BARBARICK RECYCLING AND REFUSE TRANSFER STATION

GRADING AND EROSION CONTROL PLAN

FEBRUARY 2024

PCD FILE NO. COM2346

BARBARICK WASTE TRANSFER STATION
EL PASO COUNTY, COLORADO
GRADING AND EROSION CONTROL
INTERIM GEC PLAN

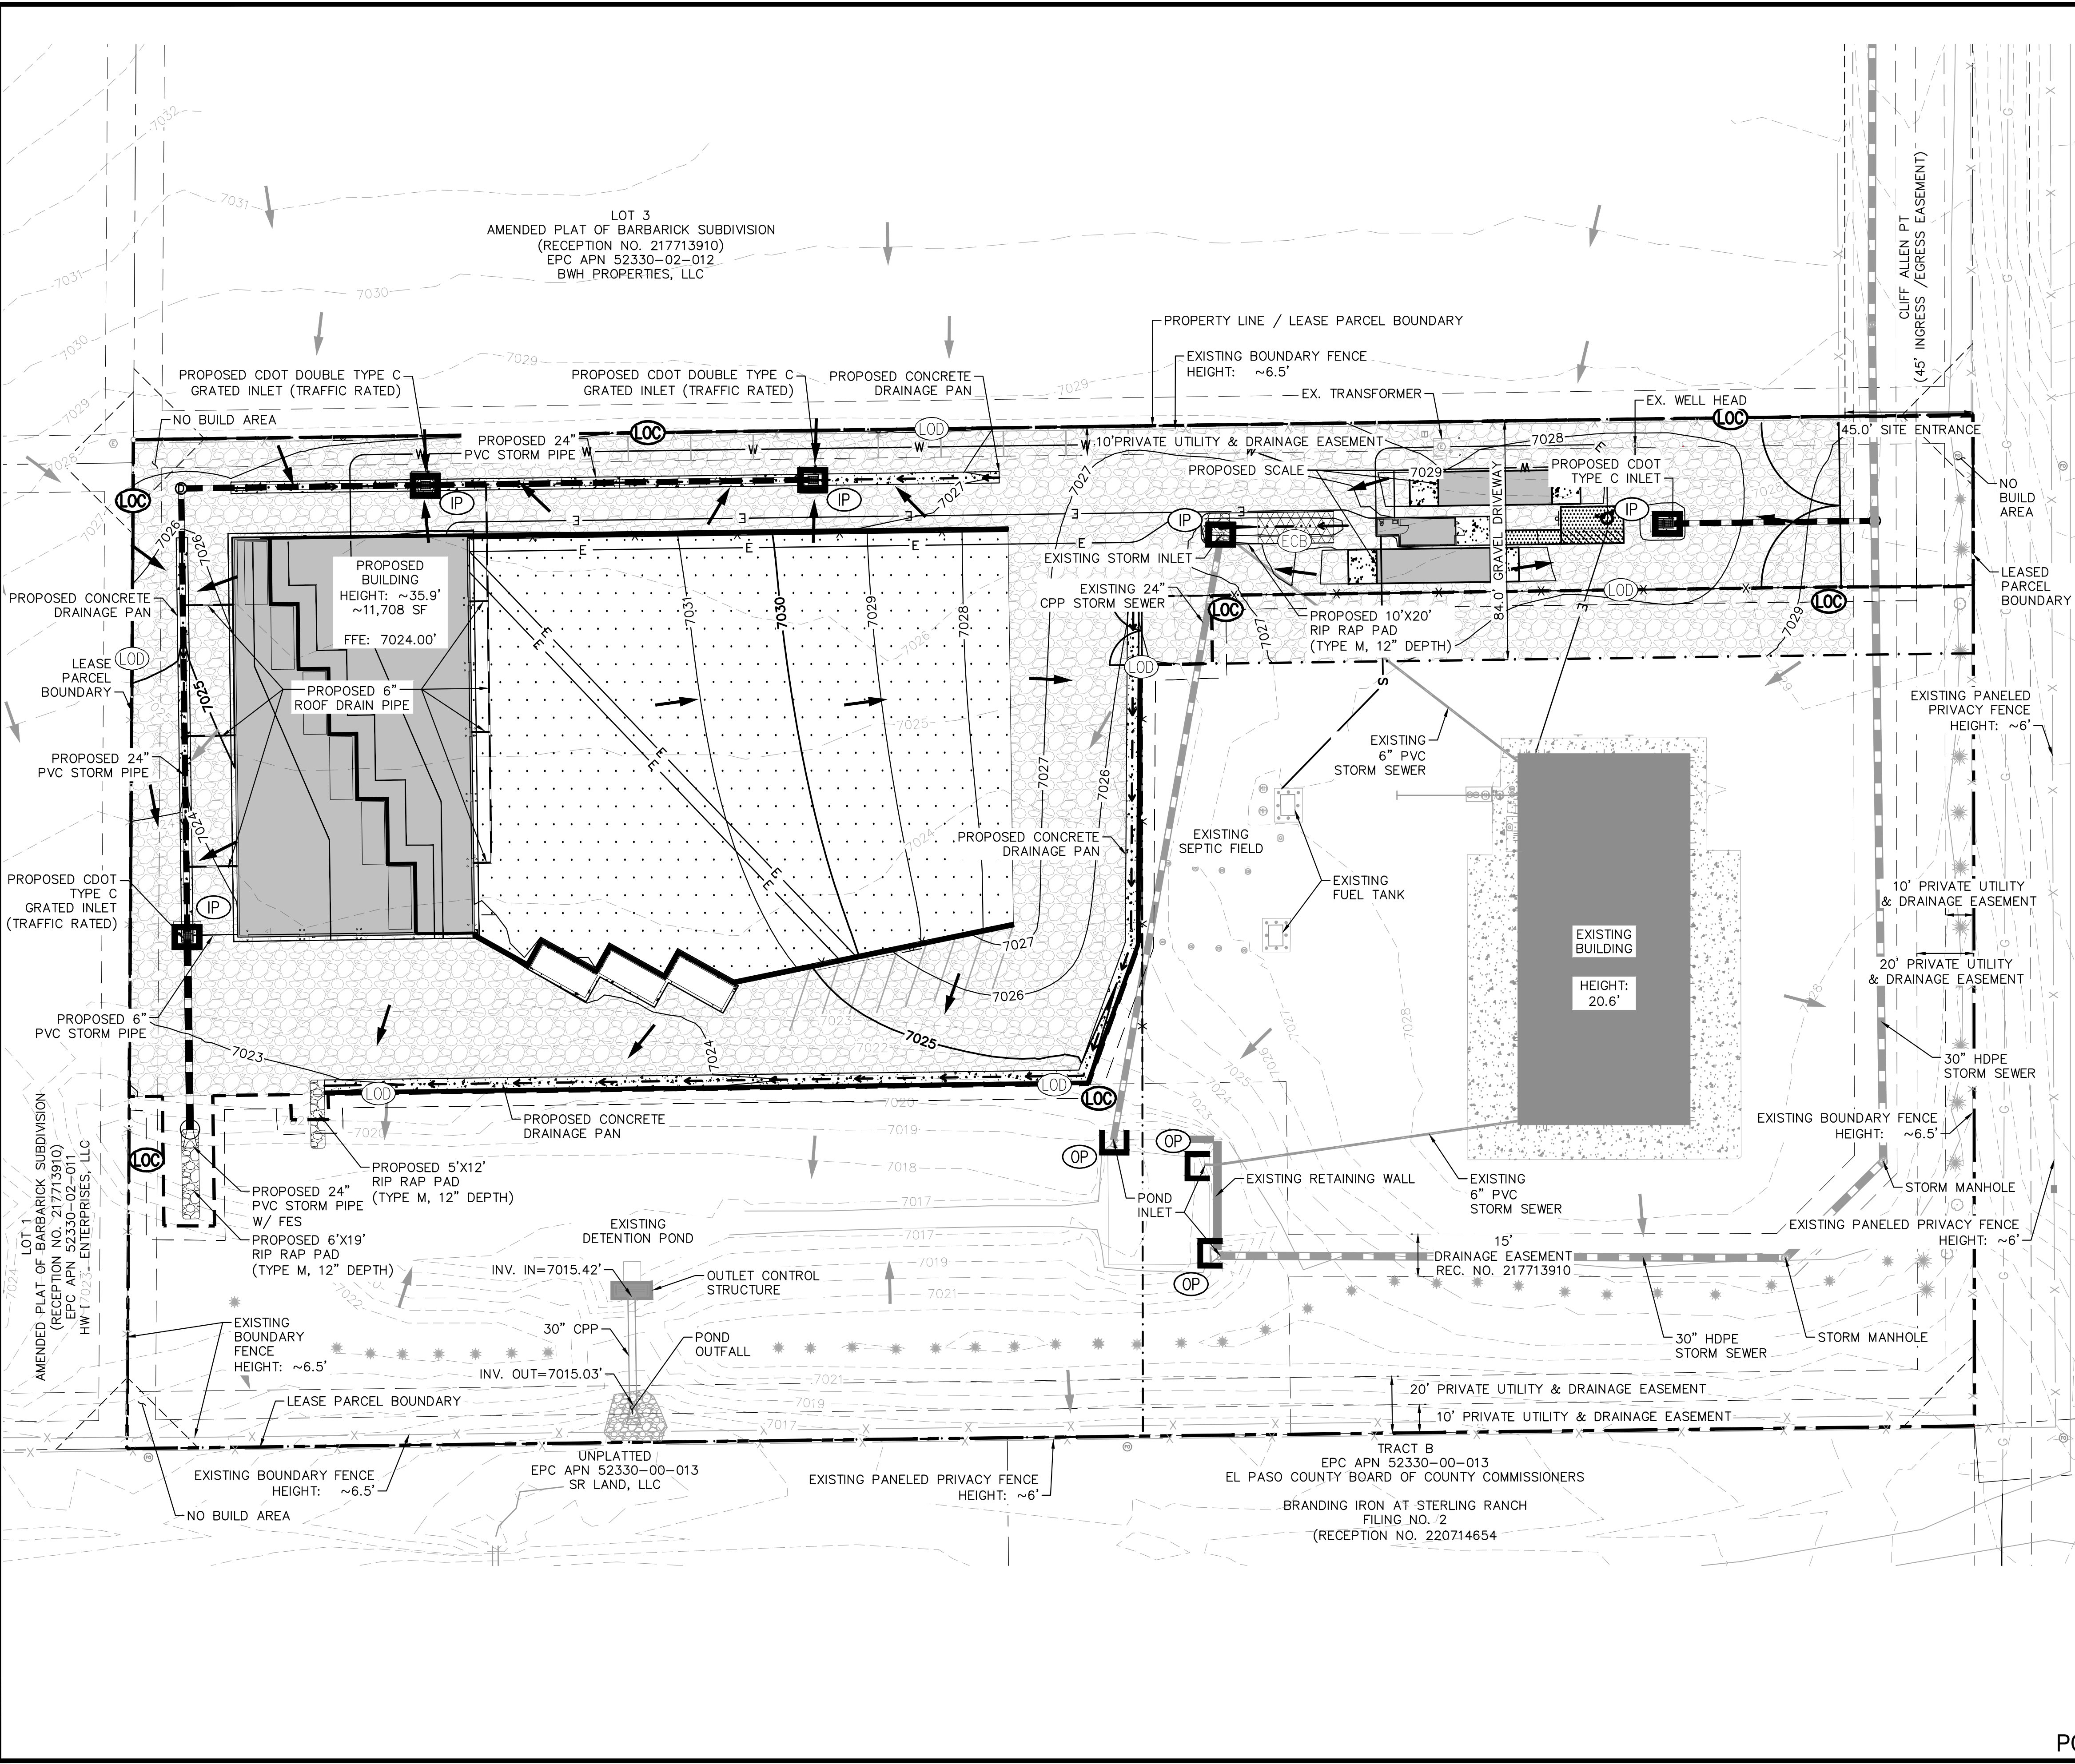
Unresolved comment from Review 1 is below. I don't see that anything has changed from the last submittal to suggest that a forebay is not needed. Please give me a call to clarify. 719-675-2654

Forebay needed when >1ac of imperviousness is tributary to a pond inflow point per MHFD Detail T-5. The non-paved areas will count towards that 1ac at whatever % impervious they have (it appears to be gravel which is 80%). The calc will likely be pretty close to 1ac.

Now is 30" in FDR Drainage Map.

Is now shown as 24" on the Drainage Map in FDR. So this needs to be revised to match.

This length was revised on the FDR Drainage Map, so this no longer matches.
